Application no: **3/2020/0921**

Address: **21 Wolf Fell Close Church Raike Chipping PR3 2DR**

Proposal: **Proposed creation of hobby room to the rear of the existing garage with the insertion of a new UPVC window to the side elevation**

PROPOSED FLOOR PLAN

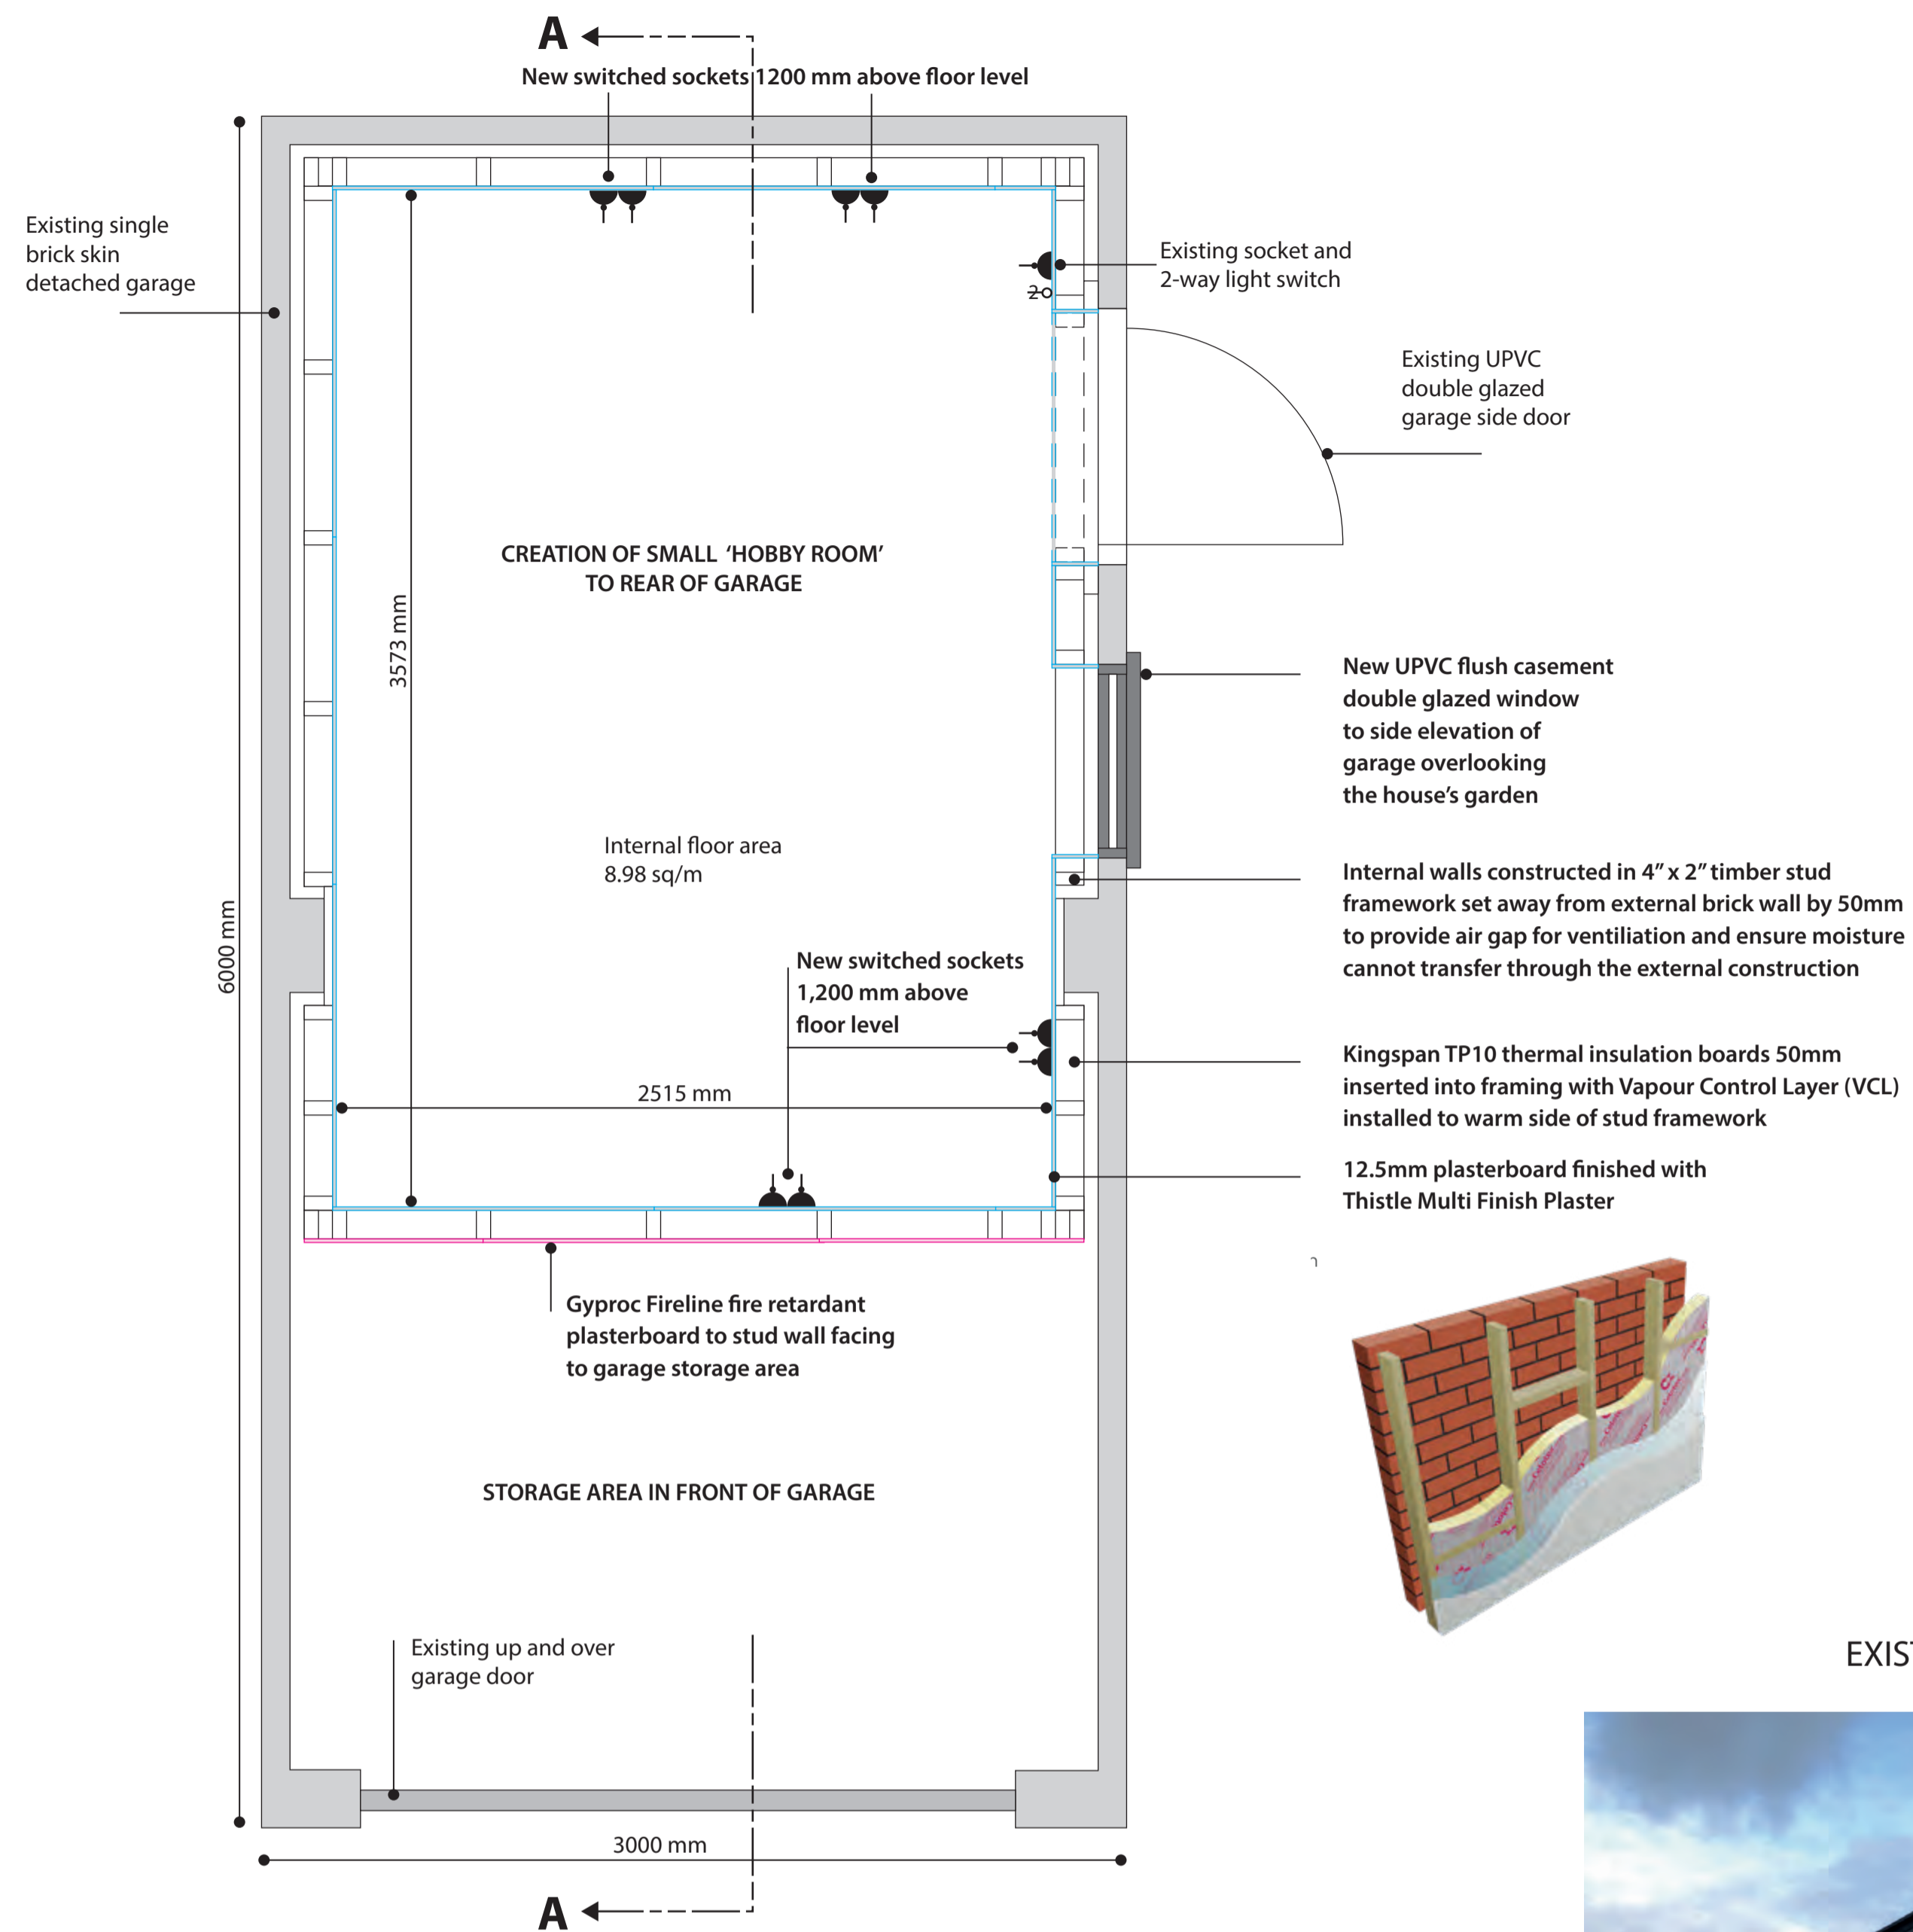
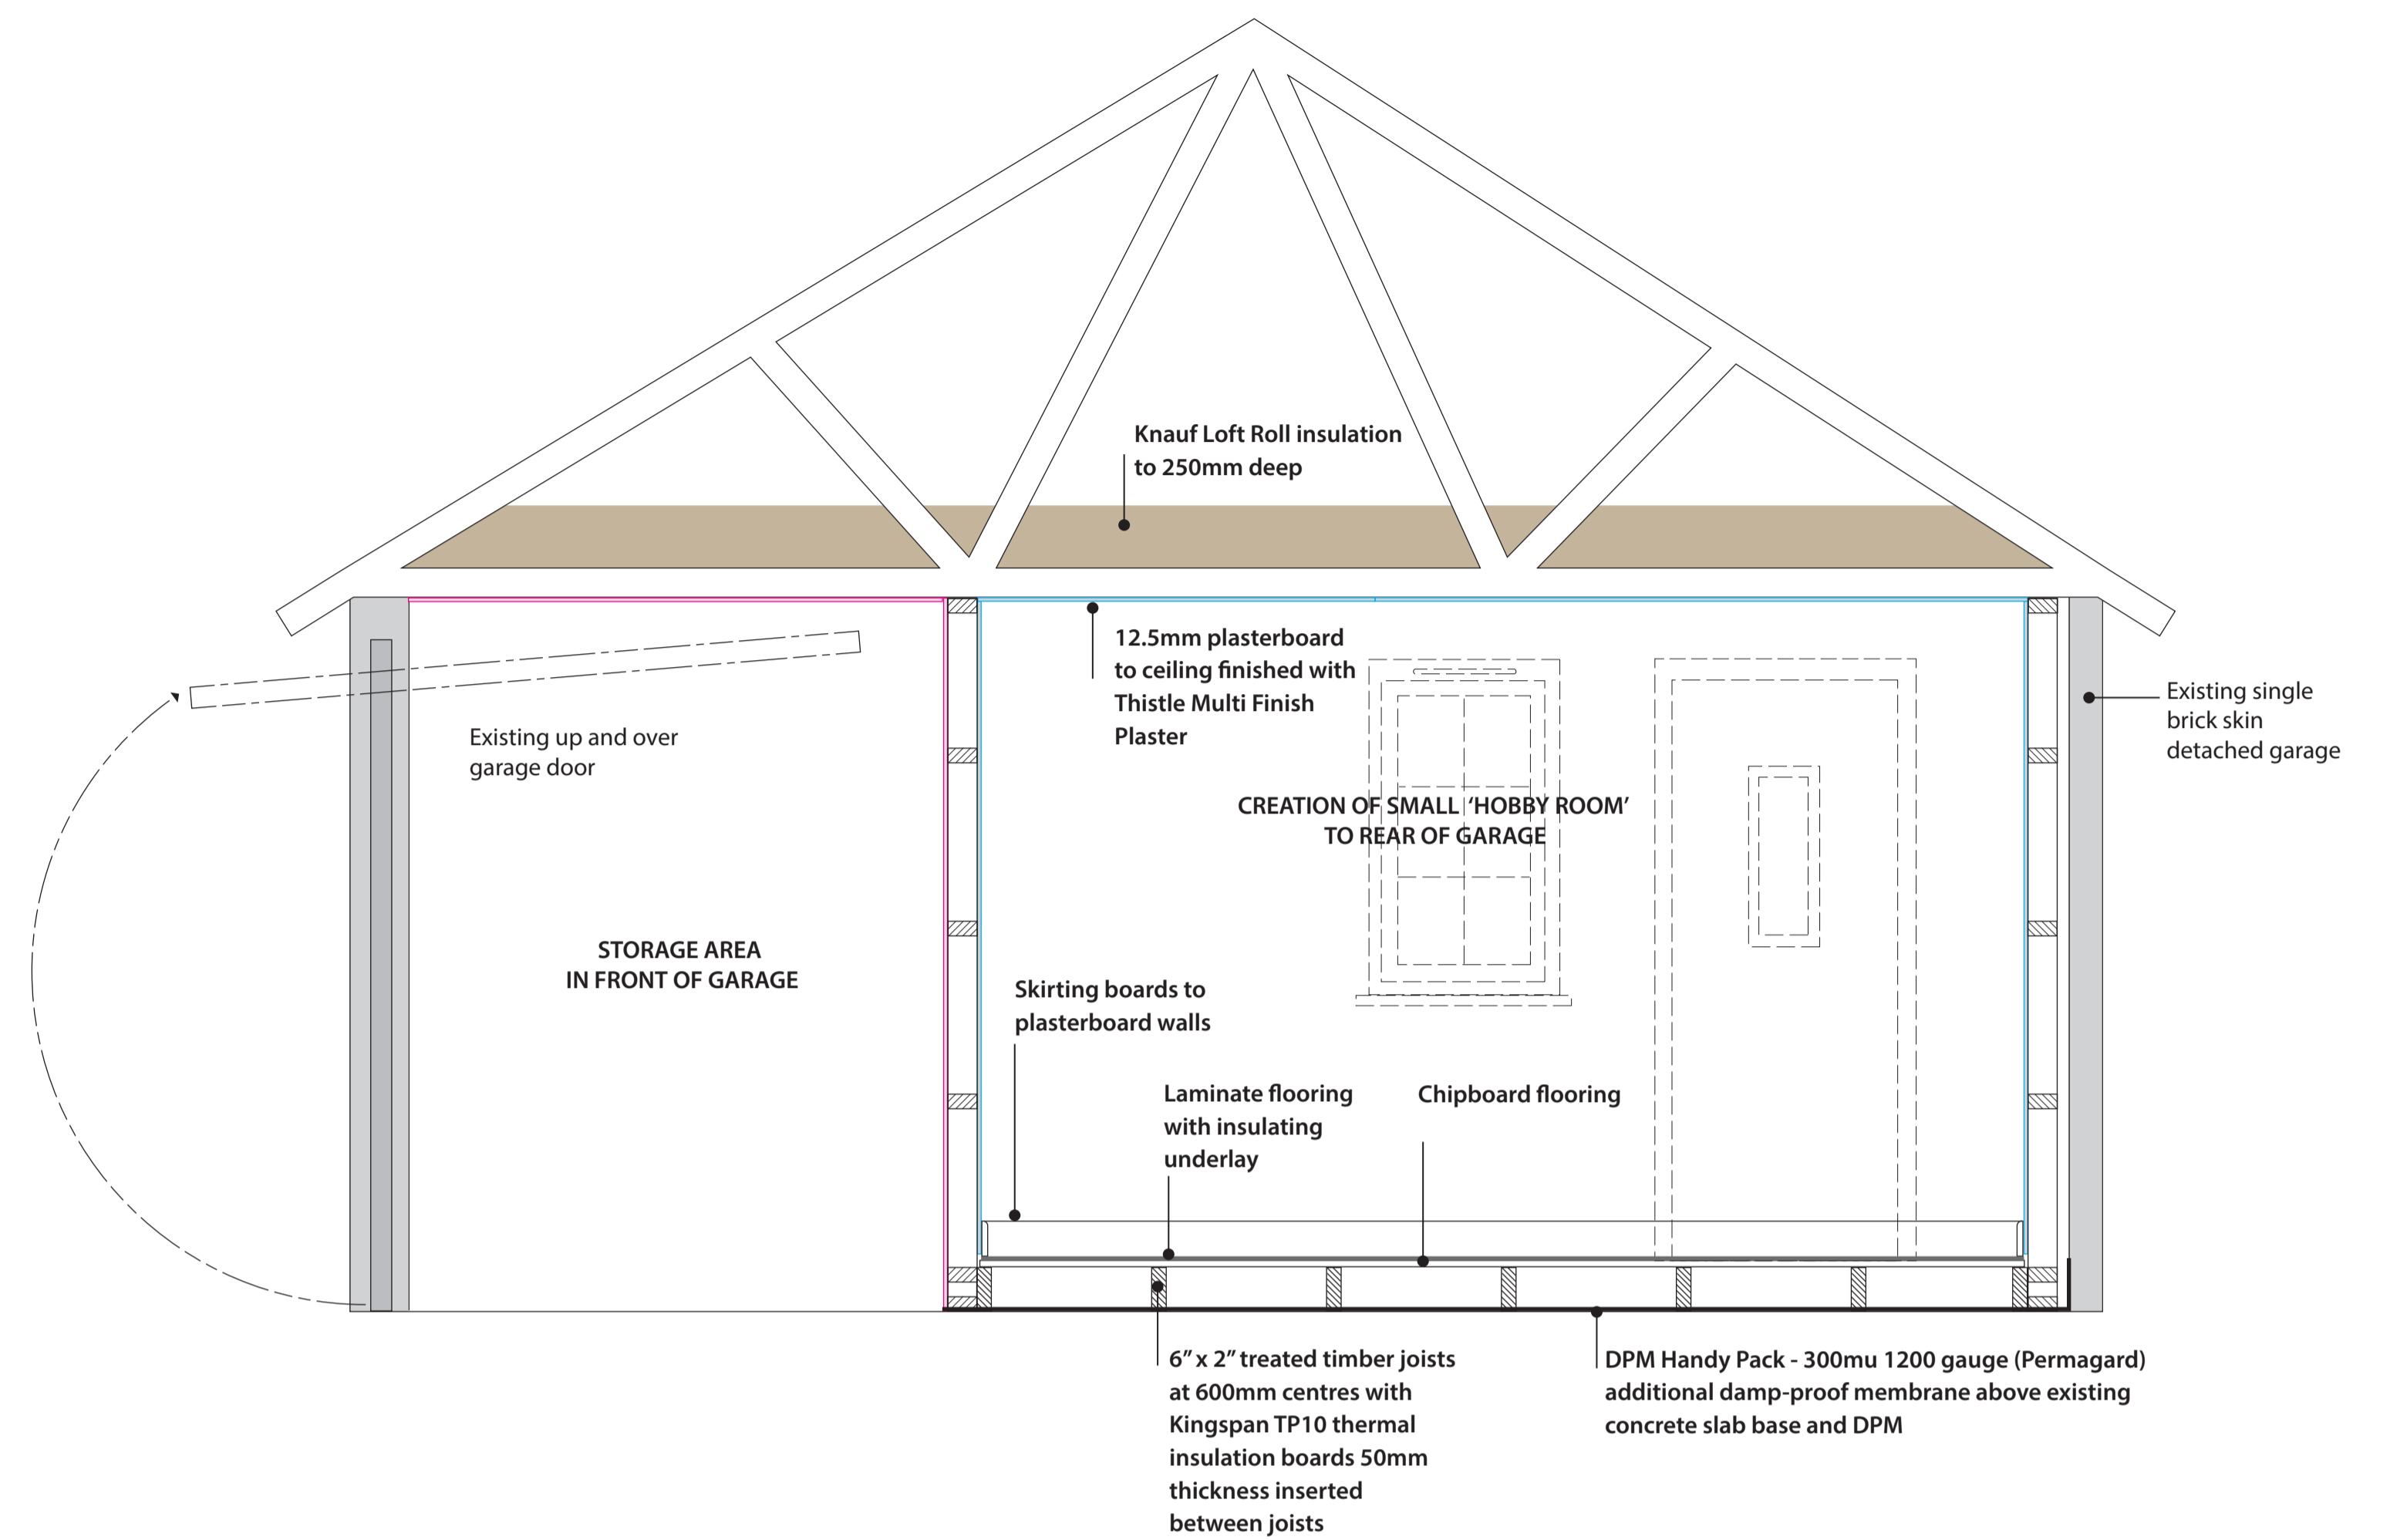
The proposed hobby room would remove a parking space with the potential for a reliance of on-street parking, the applicant is therefore required to provide details of the required parking provision before I can provide any further comments.

I ask that further information is provided, as above.
